Application no: 2026/0303

Address: 38 Mitton Road Whalley BB7 9RX

Proposal: Proposed construction of a detached building to provide annex accommodation ancillary to the main dwelling to the rear of the site.

Part Site Plan
1:100 Scale

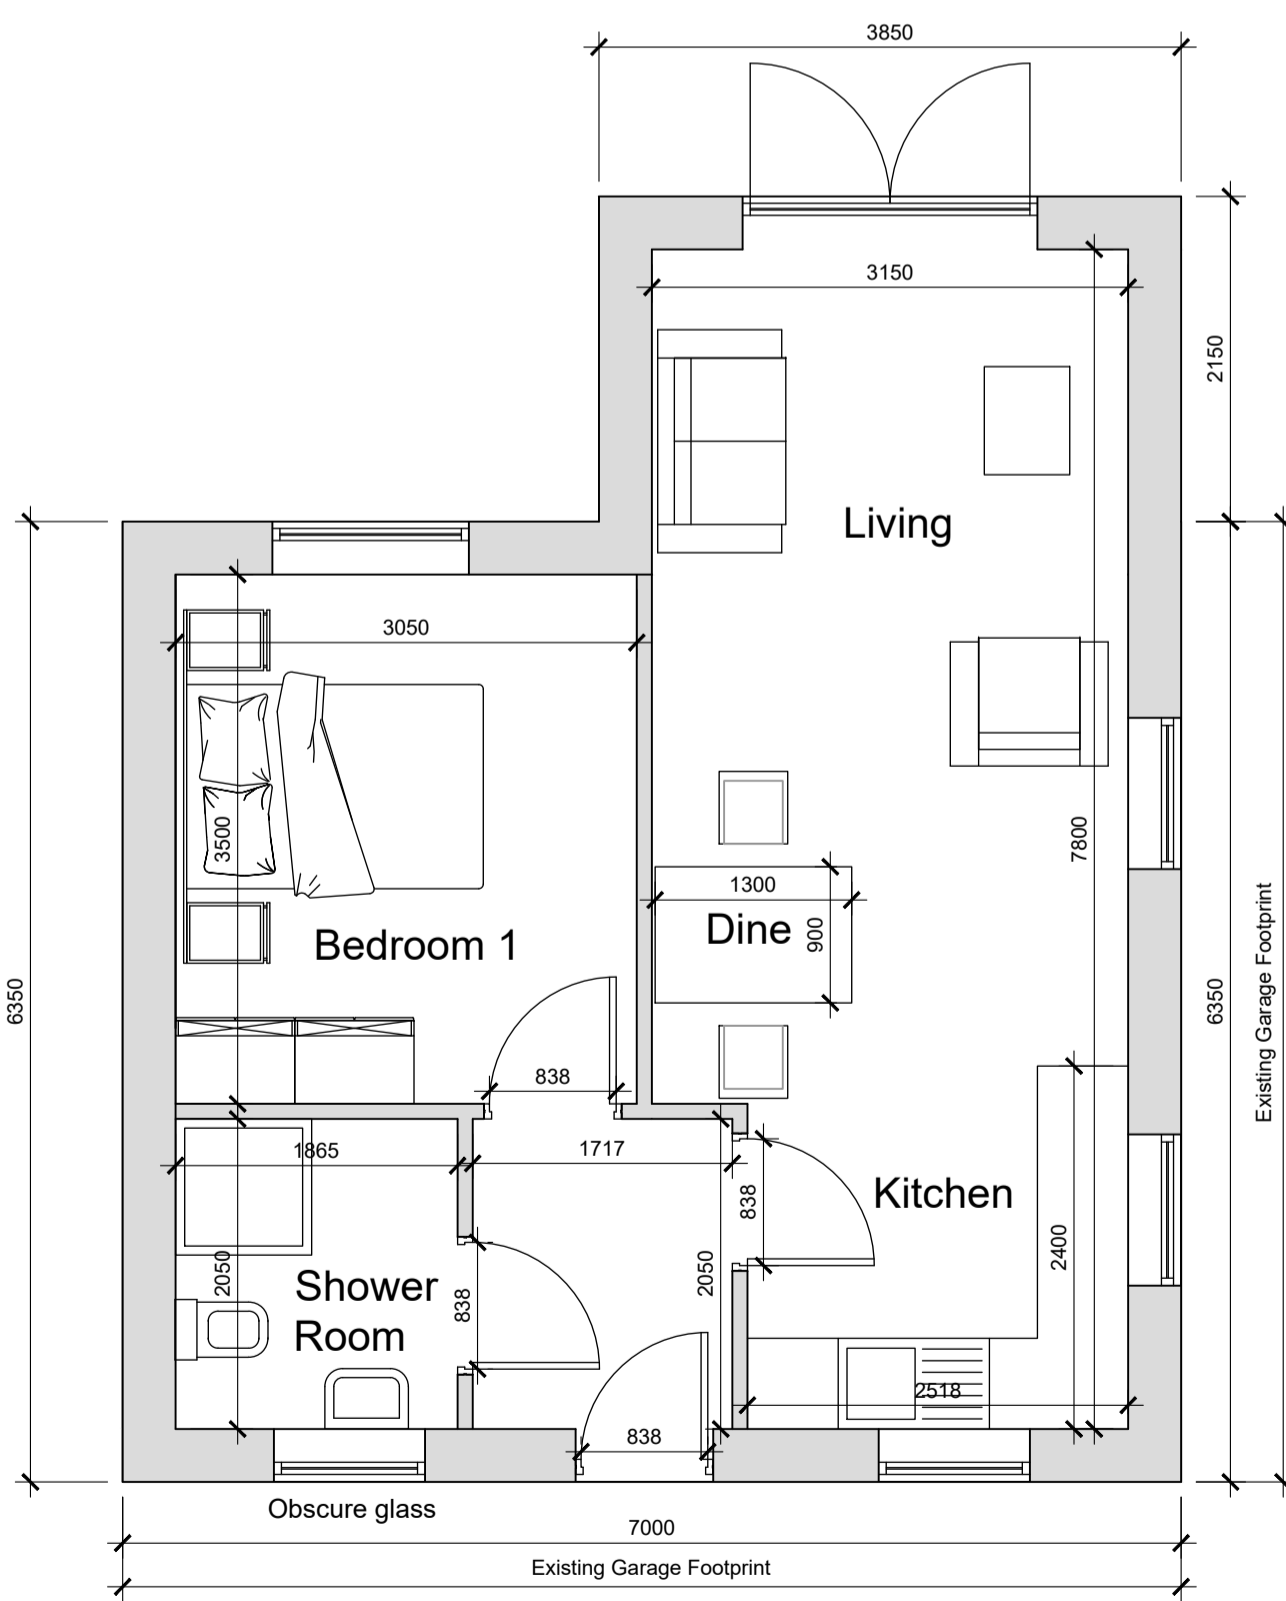
There are some concerns regarding the construction of the access there is evidence of loose material being carried on to the footway by vehicles leaving the site. In order to prevent this, we would look for the first 6m of the access from the rear of the footway to be reconstructed with a bound surface to prevent debris from being carried onto the highway.

Before the annex is used, that part of the access extending from the highway boundary for a minimum distance of 6m into the site shall be appropriately paved in tarmacadam, concrete, block paviours, or other hard material to be approved by the Local Planning Authority.
